Planning Application Reference No.: 3/2025/0867

Address of Development: Primrose Mill Business Park
Primrose Road
Clitheroe
BB7 1DR

Client Seawood Investments Ltd		
Job Title Proposed Partial Demolition of a Building to Create Space for Delivery Vehicles Primrose Business Park Primrose Road Clitheroe		
Drawing Title Proposed Site and Floor Plan and Elevations		
Scale 1:200/100@A1	Date Oct 2025	Drawn CHS/LKR

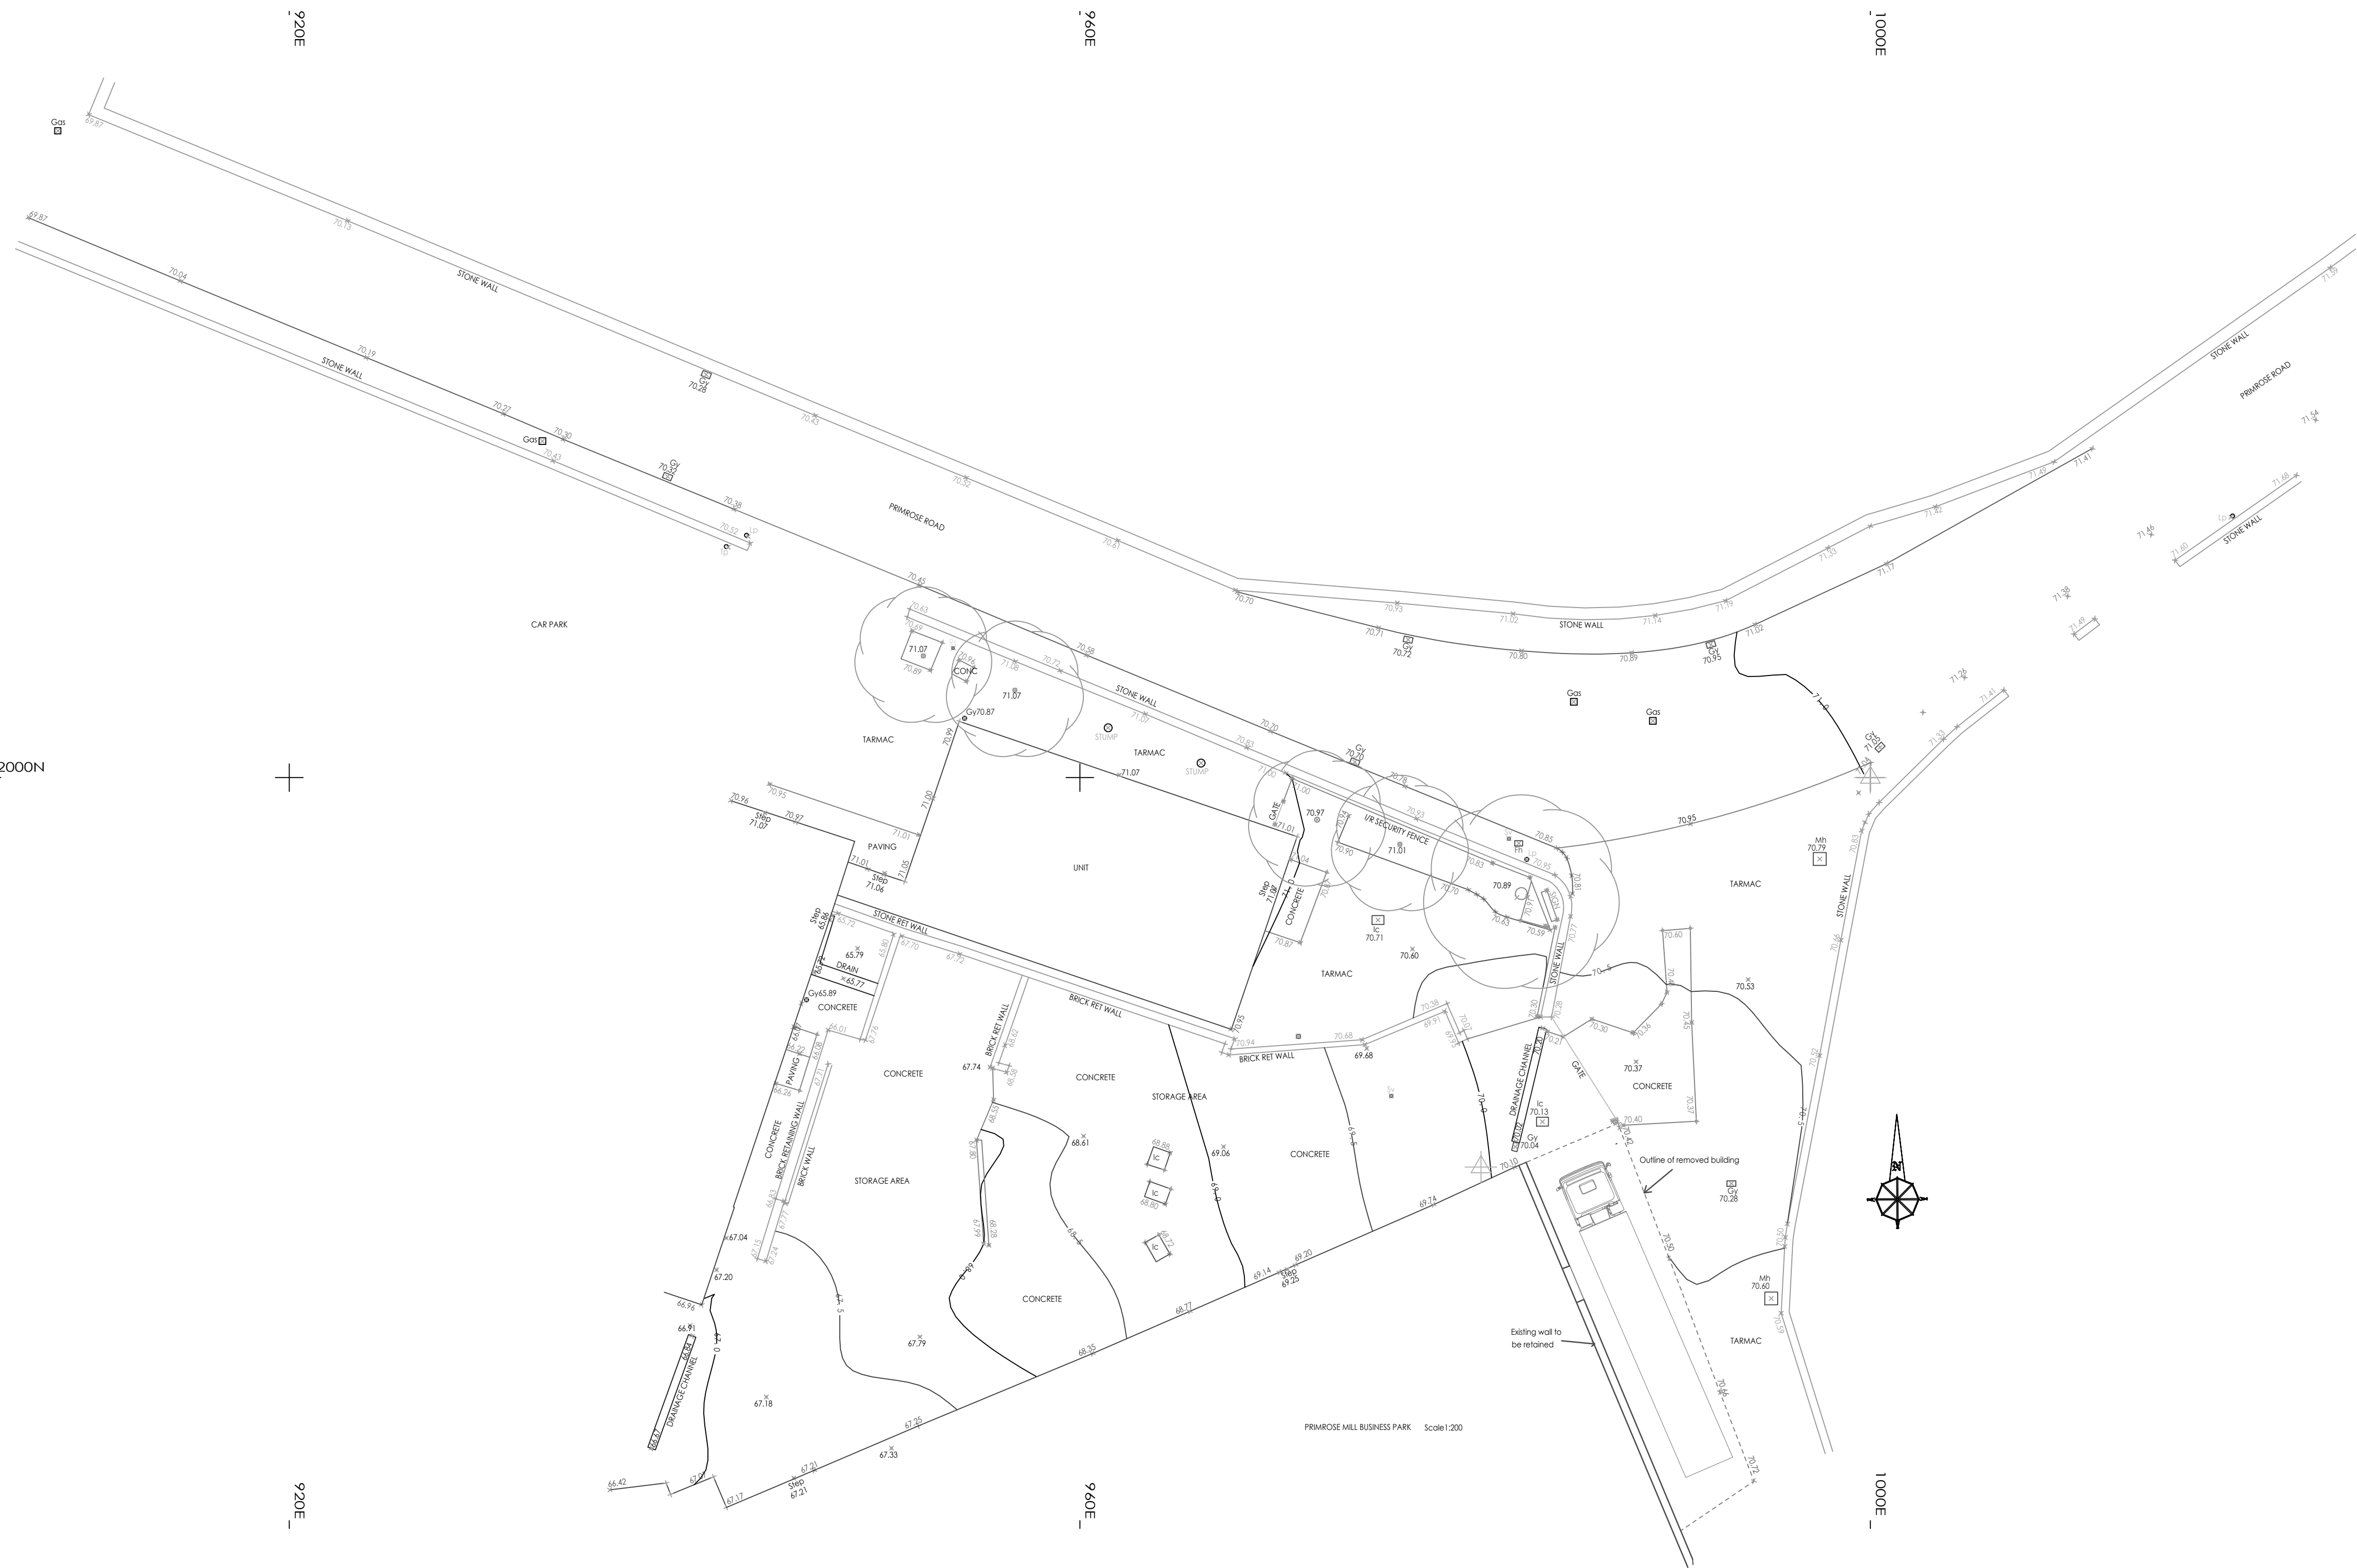
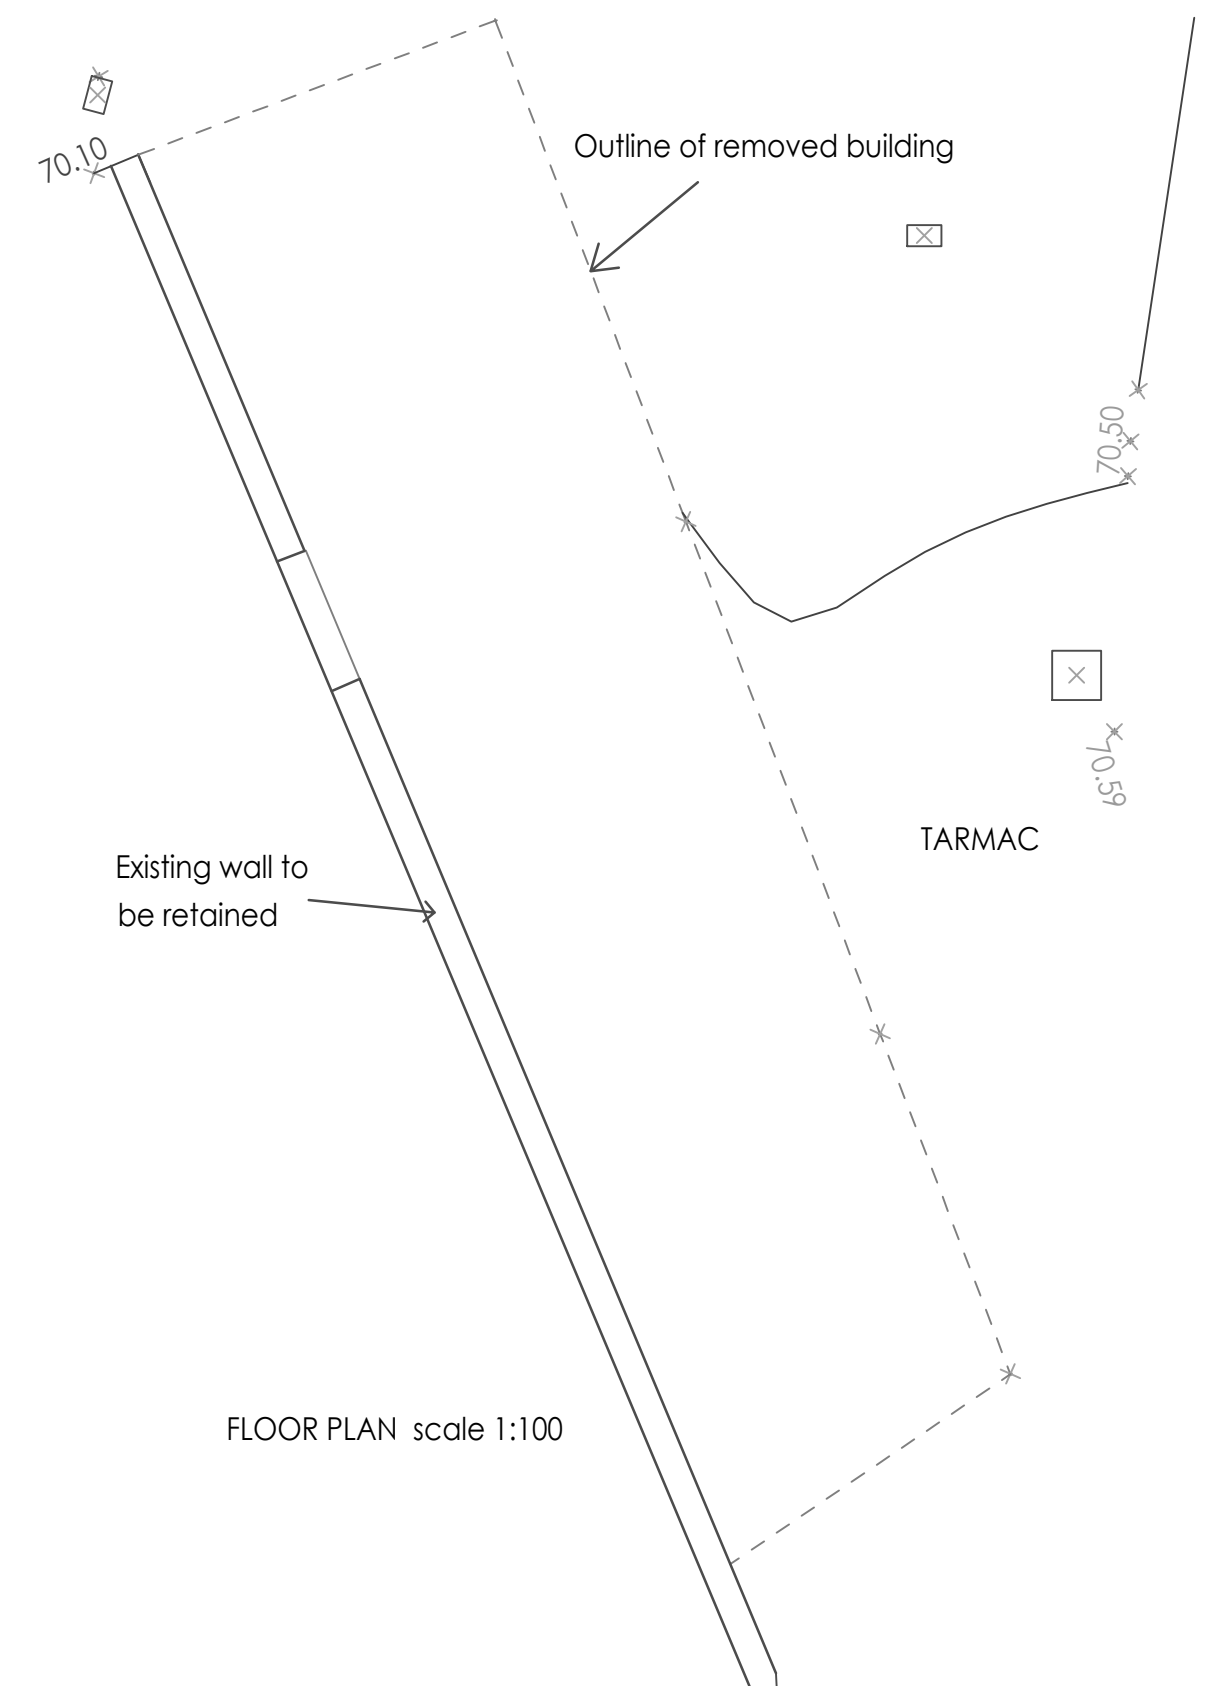
2. If lorries were to park on the footprint of the building once demolished, we are concerned that these heavy lorries could end up driving onto the bridge over Pendleton Brook which is directly bordering the edge of the existing structure. This may affect the structure of the bridge and potentially pose a safety concern and/or end up still blocking the lane up to Lower Standen Farm. We request that this application be amended to include the installation of bollard(s) to prevent lorries being able to drive onto the bridge.

5. The proposed plan shows a large Lorry parked fully up to the edge of the river bank, and I see no mention in the proposal of any attempt to inspect properly the structural integrity of the bank, with regards to its load bearing capacity. The structure to be demolished has only, to this point, been used to store light materials such as pallets.
